FOSSE GREEN ENERGY DEVELOPMENT CONSENT ORDER

PINS REFERENCE EN010154

**DEADLINE 3A: NATIONAL HIGHWAYS'
COMMENTS ON SUBMISSIONS MADE BY THE
APPLICANT AT DEADLINE 2**

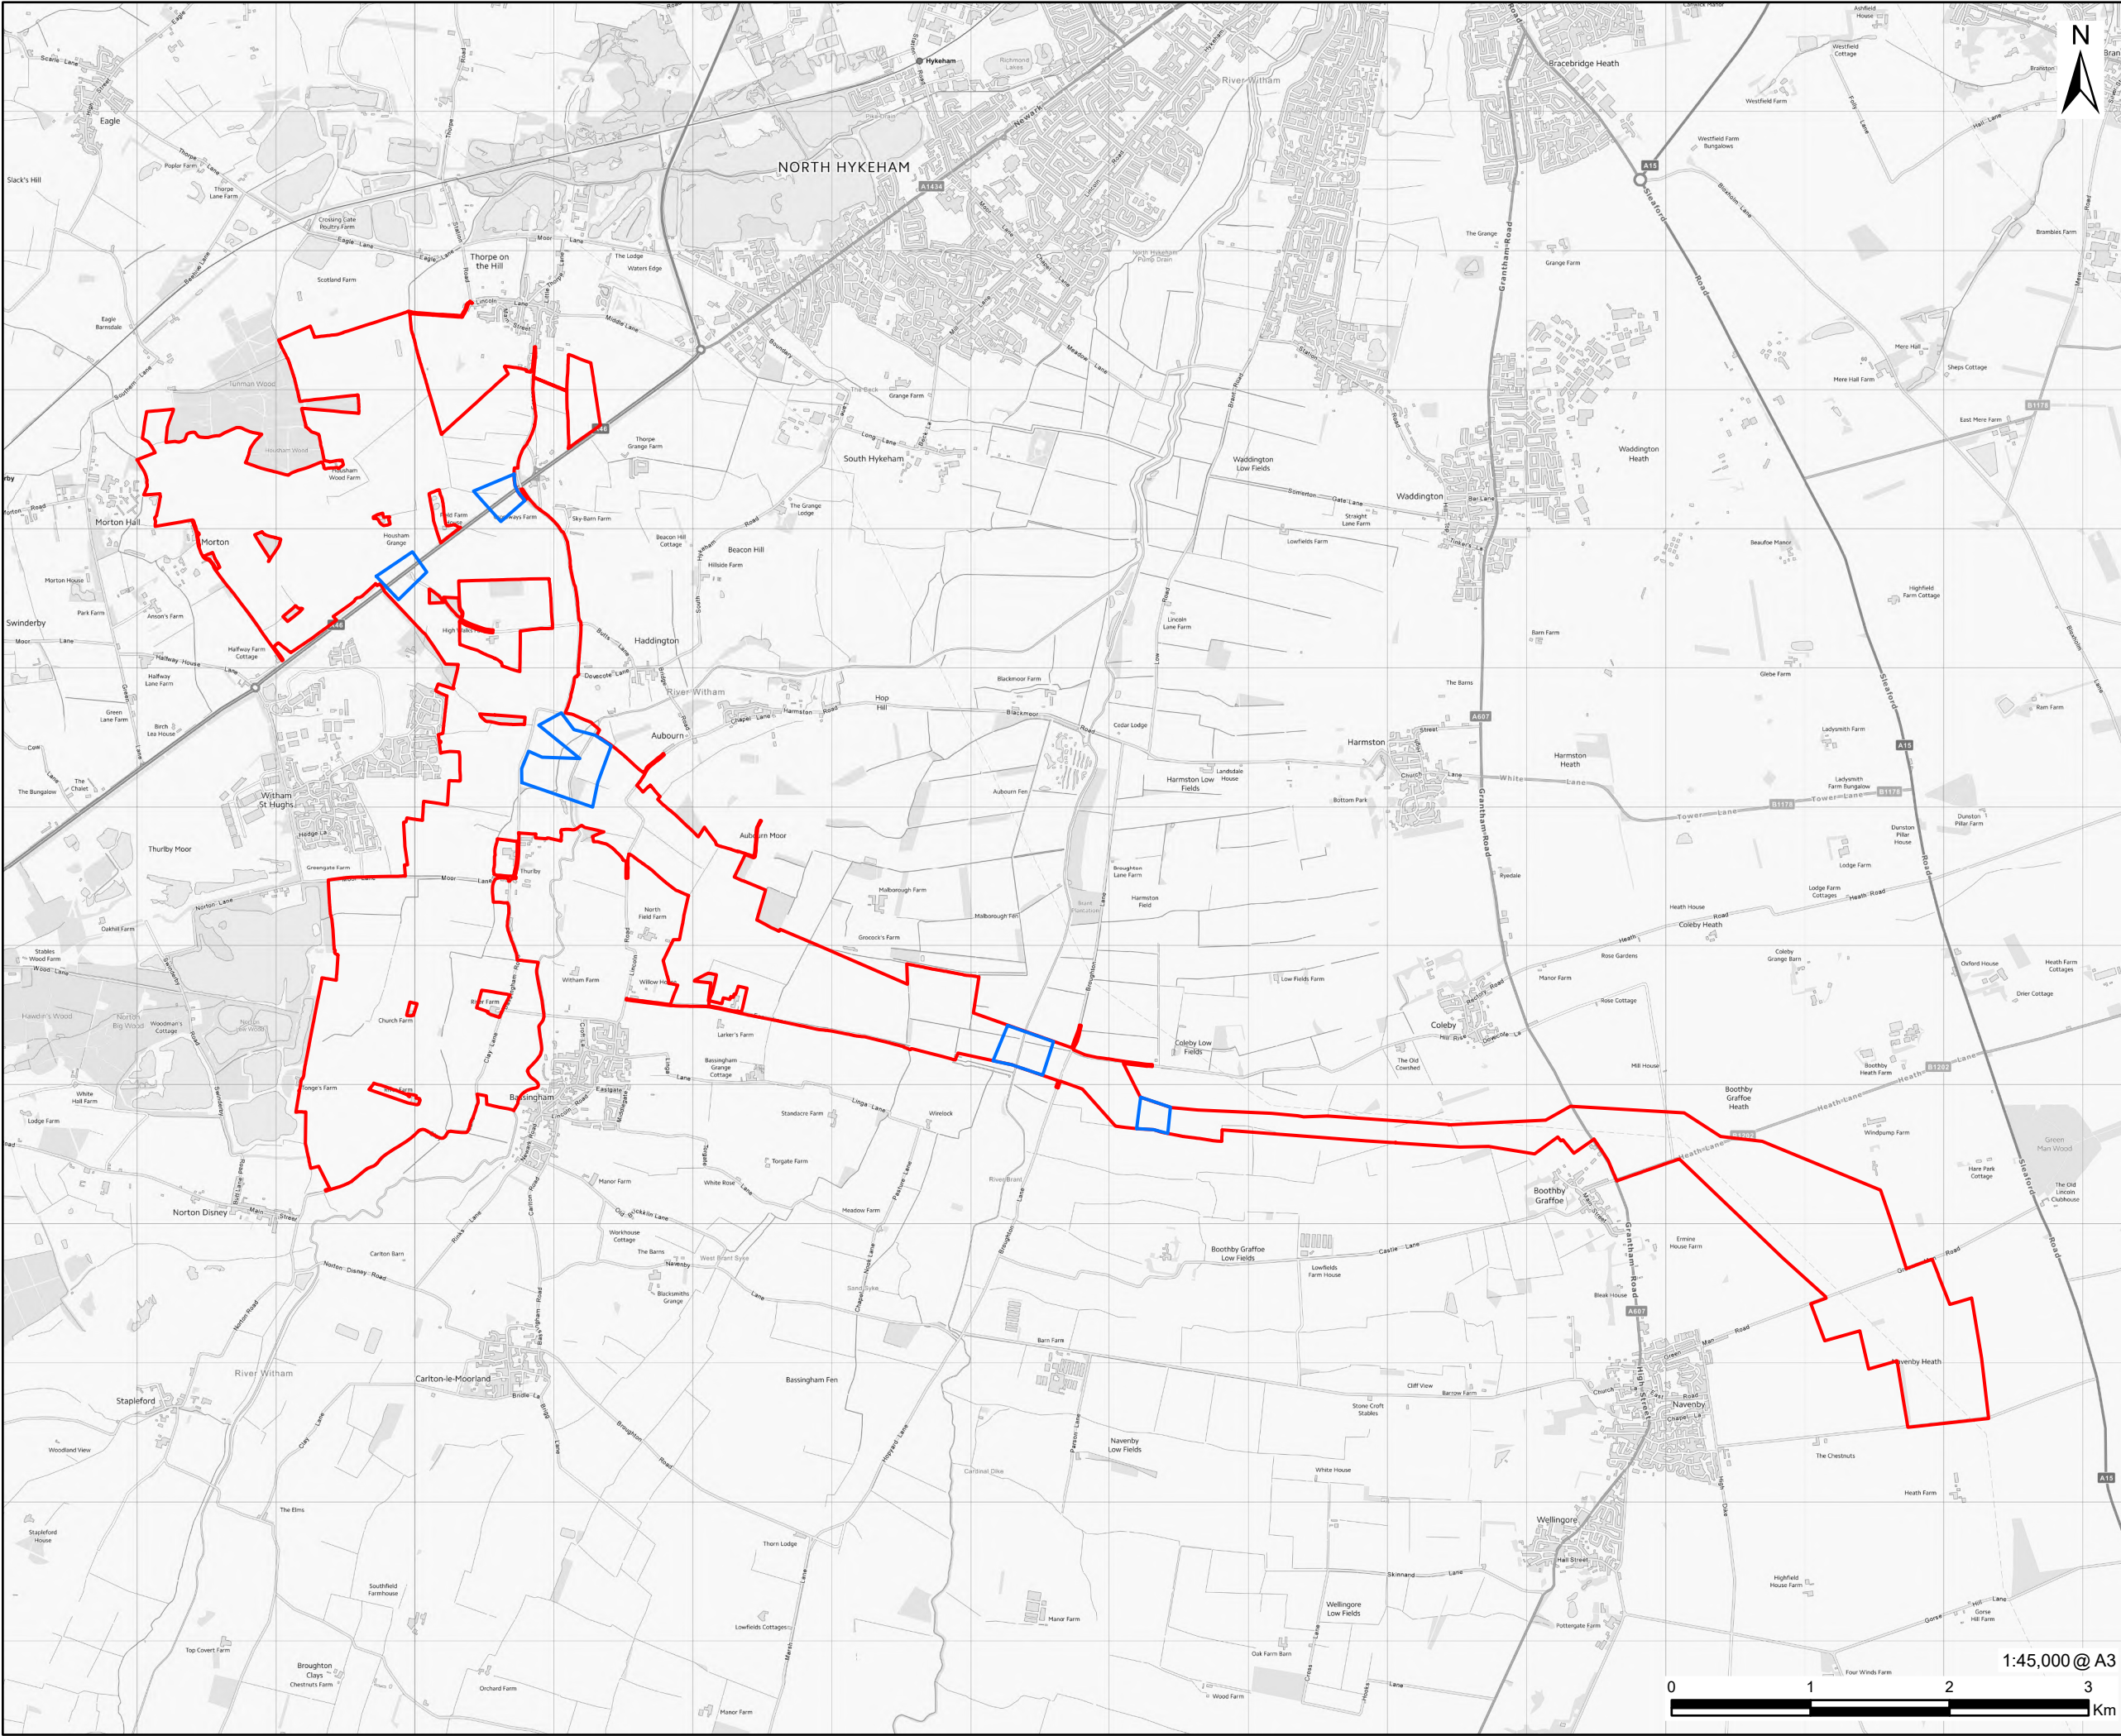
<p>and other relevant requirements for any proposed directional drilling under the NH network. The Applicant will secure these approvals and requirements through the protective provisions to be agreed with NH and inserted into Schedule 14 of the Draft DCO [REP1-007].</p> <p>The Applicant has responded to comments relating to Work No. 6 in Table 2-7, Section 2 on Page 74 of the Applicant's Response to Relevant Representations [REP1-047] as follows:</p> <p>With regards to consideration of the potential impact of drilling upon other SRN assets, such as drainage, it should be noted that a full clash detection exercise would be procured at the detailed design stage, when the design detail for the Proposed Development is more precise. The Framework CEMP [REP1-031] (ref. MAD-C1) notes: "To identify any existing infrastructure constraints, both consultation and a desk-based study will be undertaken prior to construction so that appropriate mitigation such as buffers can be incorporated into the design. Cable Avoidance Tool (CAT) scans will also be used by Contractors to check for buried utilities prior to earth breaking site activities. The Applicant will endeavour to engage with utilities providers as appropriate." The clash detection exercise would be undertaken at the earliest appropriate opportunity during the detailed design stage of the Proposed Development and any NH assets identified would be appropriately avoided by design. Production of a detailed CEMP, which is to be developed substantially in accordance with the Framework plan, is secured under Requirement 12 of the Draft DCO [REP1- 007]. Under the same Requirement, the detailed CEMP is to be submitted to the relevant planning authority (North Kesteven District Council) for approval, in consultation with Lincolnshire County Council, National Highways and the Environment Agency. The construction of the Proposed Development must be carried out in accordance with the approved CEMP.</p> <p>The protective provisions to be included in the DCO for NH apply to "specified works" which are defined as "the installation of underground 33 kilovolt (kV) interconnection cables under the A46 or so much of any work, including highway works and signalisation, authorised by this Order including any maintenance of that work, as is on, in, under or over the strategic road network for which National Highways is the highway authority or land in which National Highways has an interest". No specified works may commence until a condition survey and monitoring regime of any NH assets or structures that NH considers will be affected by the specified works have been agreed with NH.</p> <p>With regard to safety risks, the protective provisions include road safety audits (RSAs) at stages 1, 2 and 3 to be carried out in respect of all specified works. Any recommendations or exceptions raised by the RSAs must be approved by NH. In addition, specified works will be inspected by NH during construction and on practical completion, the latter initiating the process (for the Applicant) of applying for provisional and final certificates to be issued subject to NH approval.</p>
